# CITY OF ALBUQUERQUE

**RE: Burger King – 5508 4<sup>th</sup> Street NW**  
**Grading and Drainage Plan**  
**Stamp Date: 10/30/17**  
**Hydrology File: F14D055**

Based upon the information provided in your submittal received 10/30//2017, the Grading Plan **is not** approved for Building and SO-19 Permit. The following comments need to be addressed for approval of the above referenced project:

11-09-17 Richard Dourte P.E. #10854	Title BURGER KING 4TH ST. AND MONTANO RD 5508 4th Street NW	DRAWN BY DATE OCT. 2017
	GRADING AND DRAINAGE PLAN	
	RHD Engineering, LLC 4305 Purple Sage Ave. NW ALBUQUERQUE, NM 87120 (505) 288-1621	SHEET # 1 of 2 JOB #

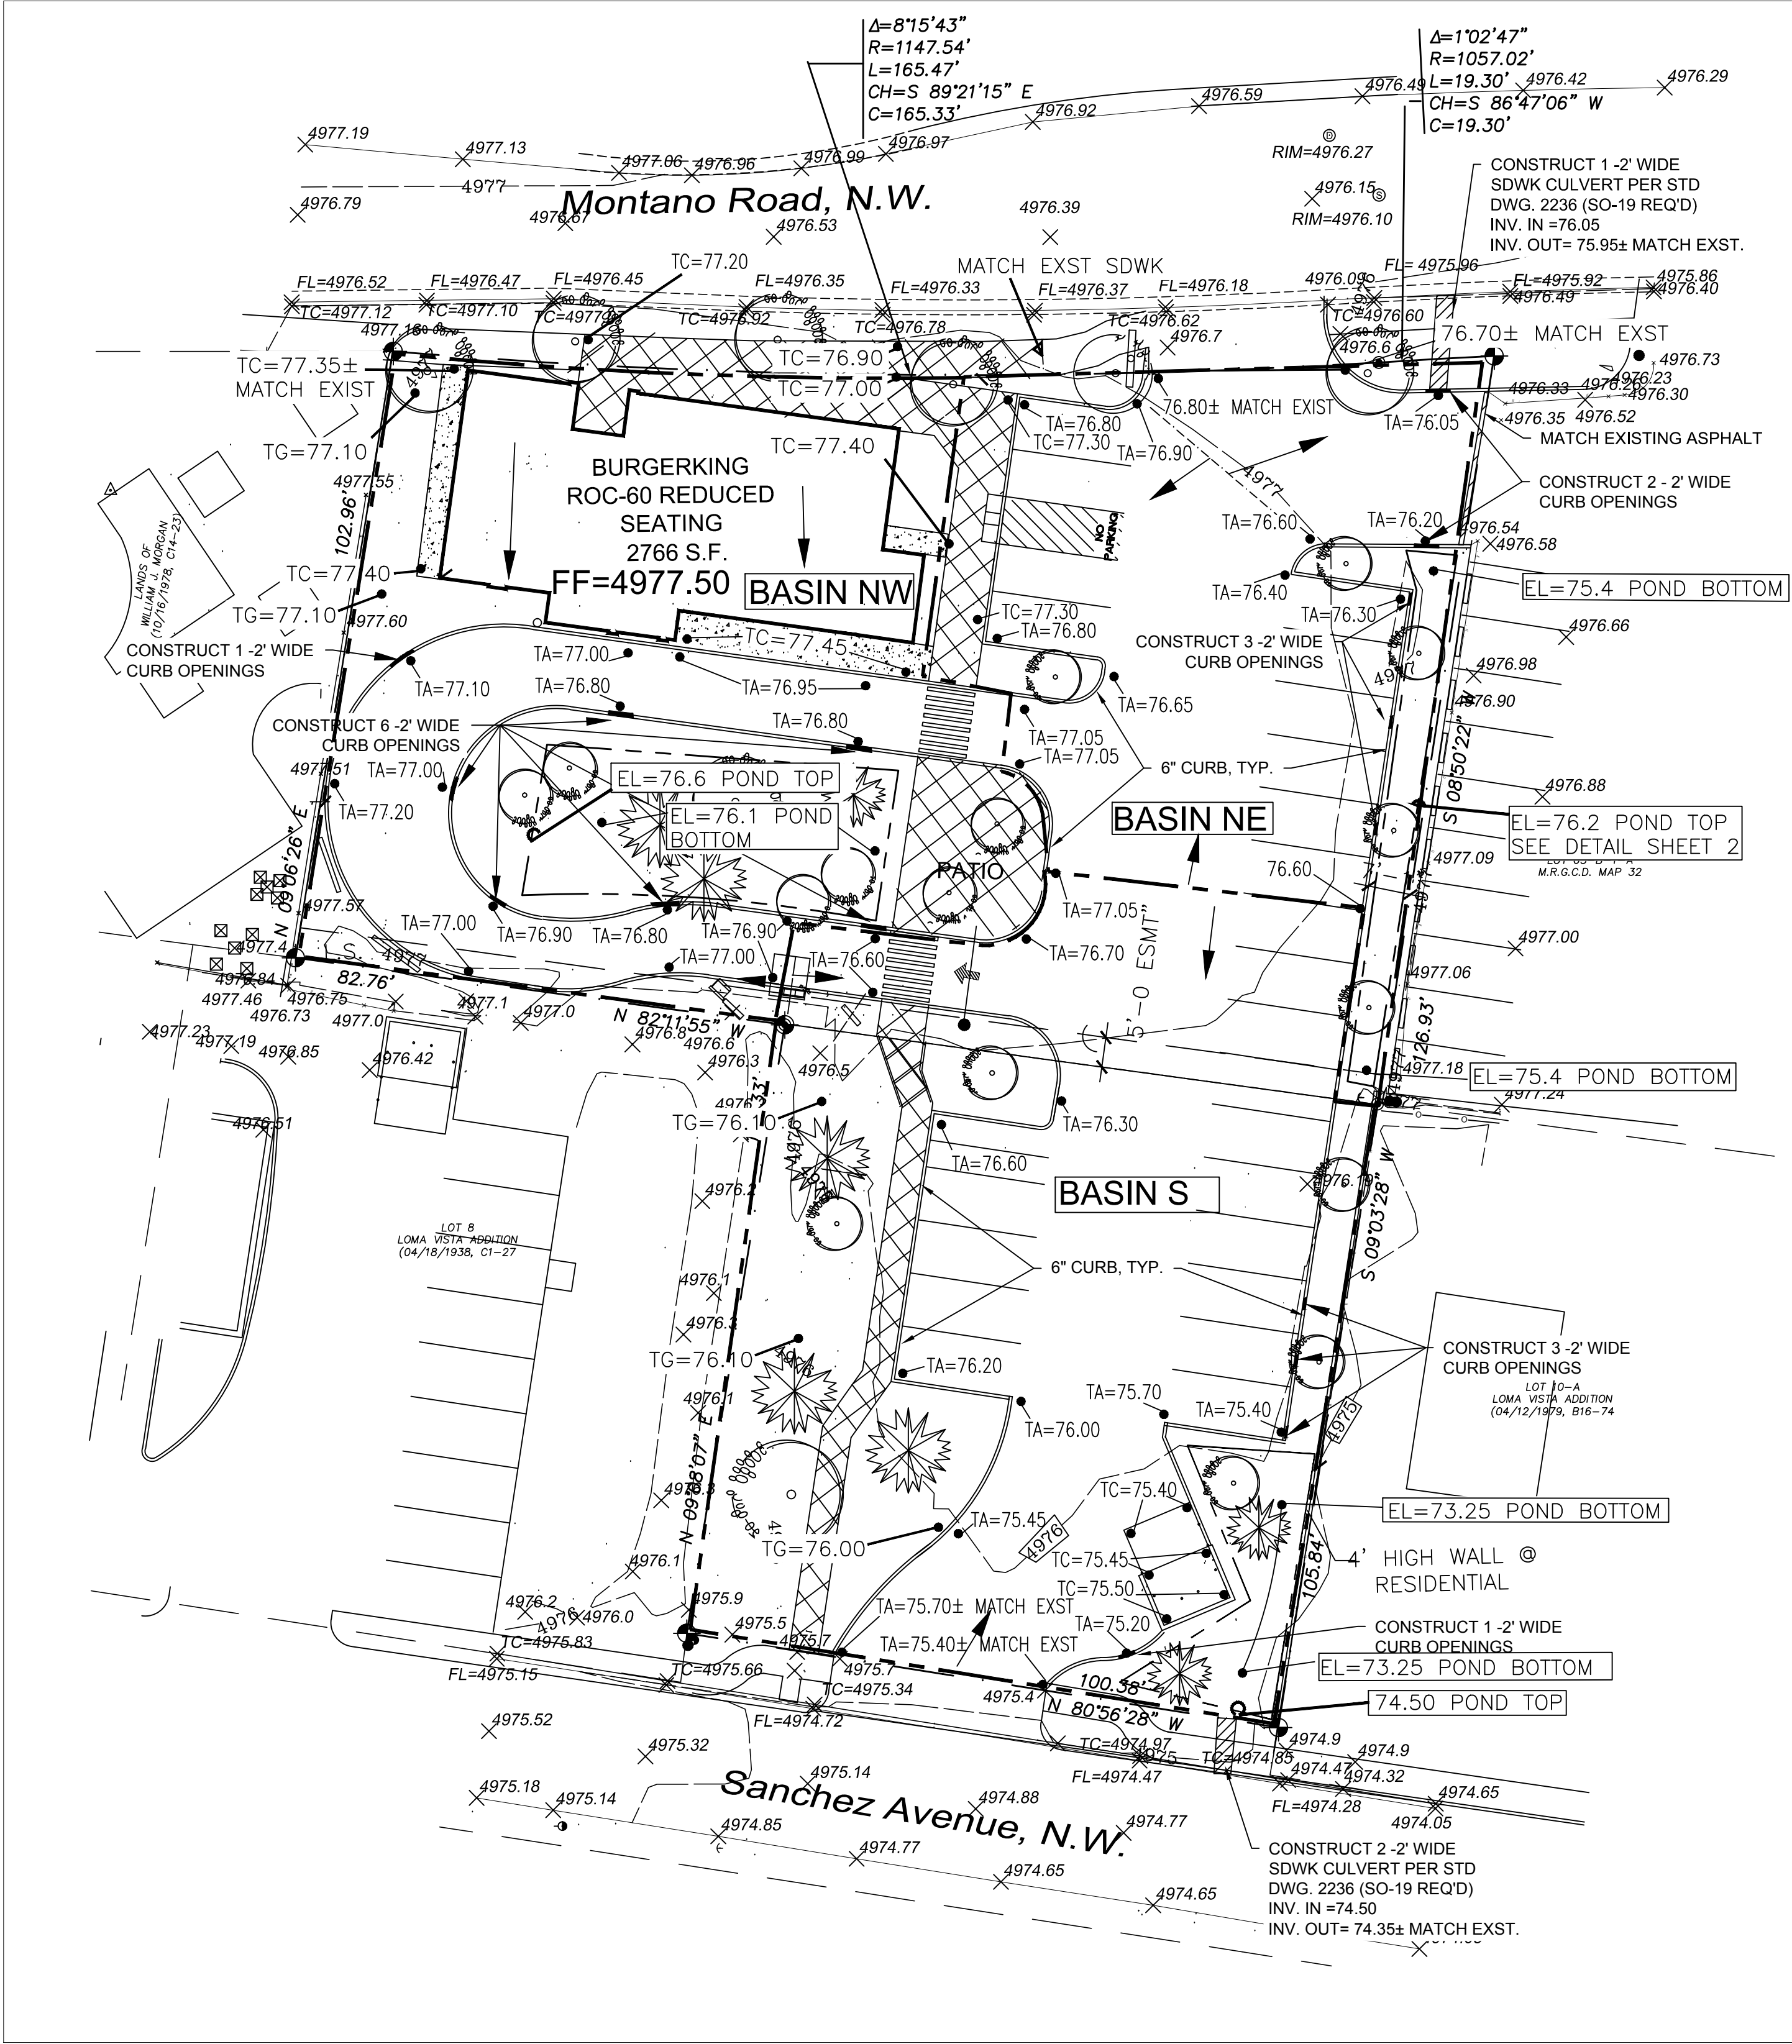
1. Please darken the property line or make the proposed basin boundary go around the property line. It is hard to tell what is within the site.

WEIR CALCULATIONS

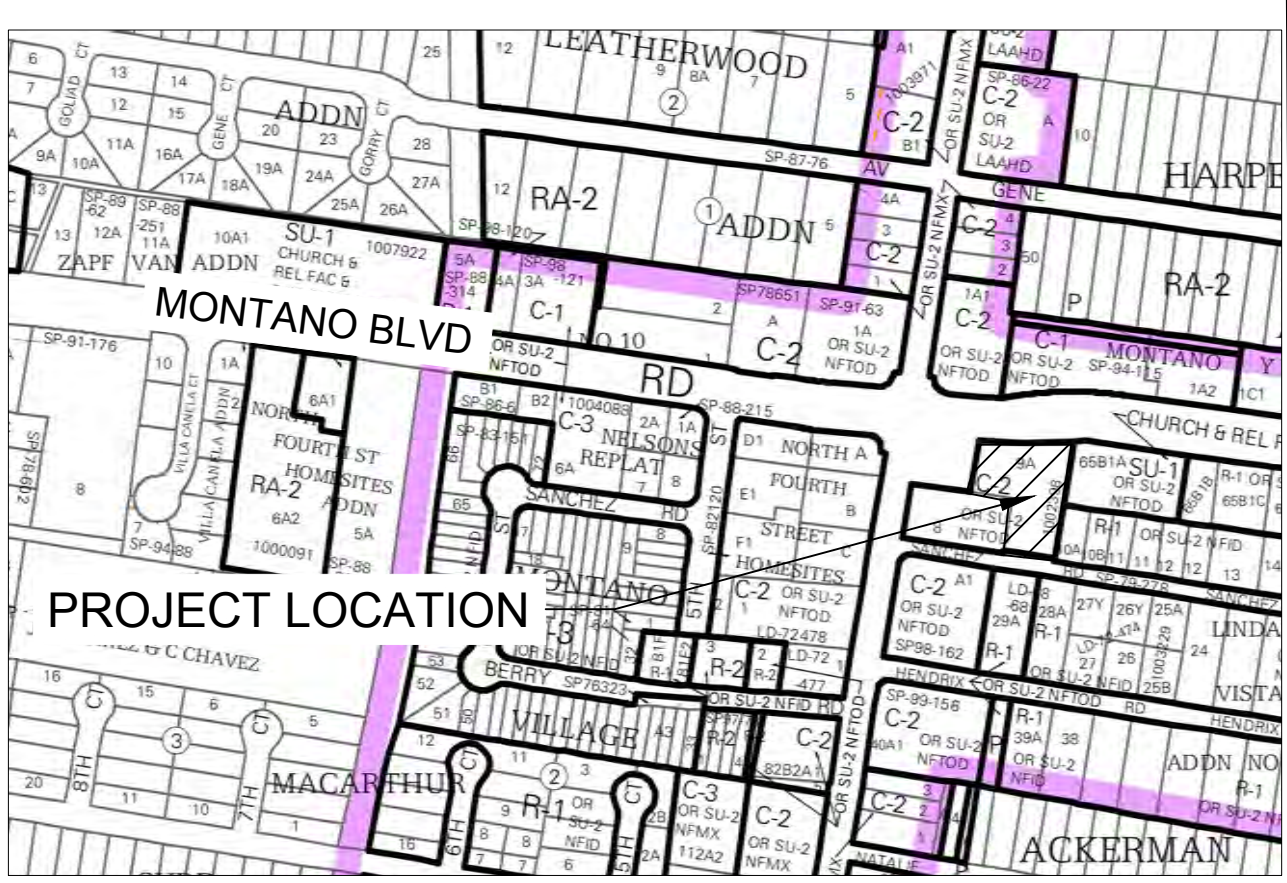
2. Please provide the weir calculations for the curb cuts and sidewalk culverts.
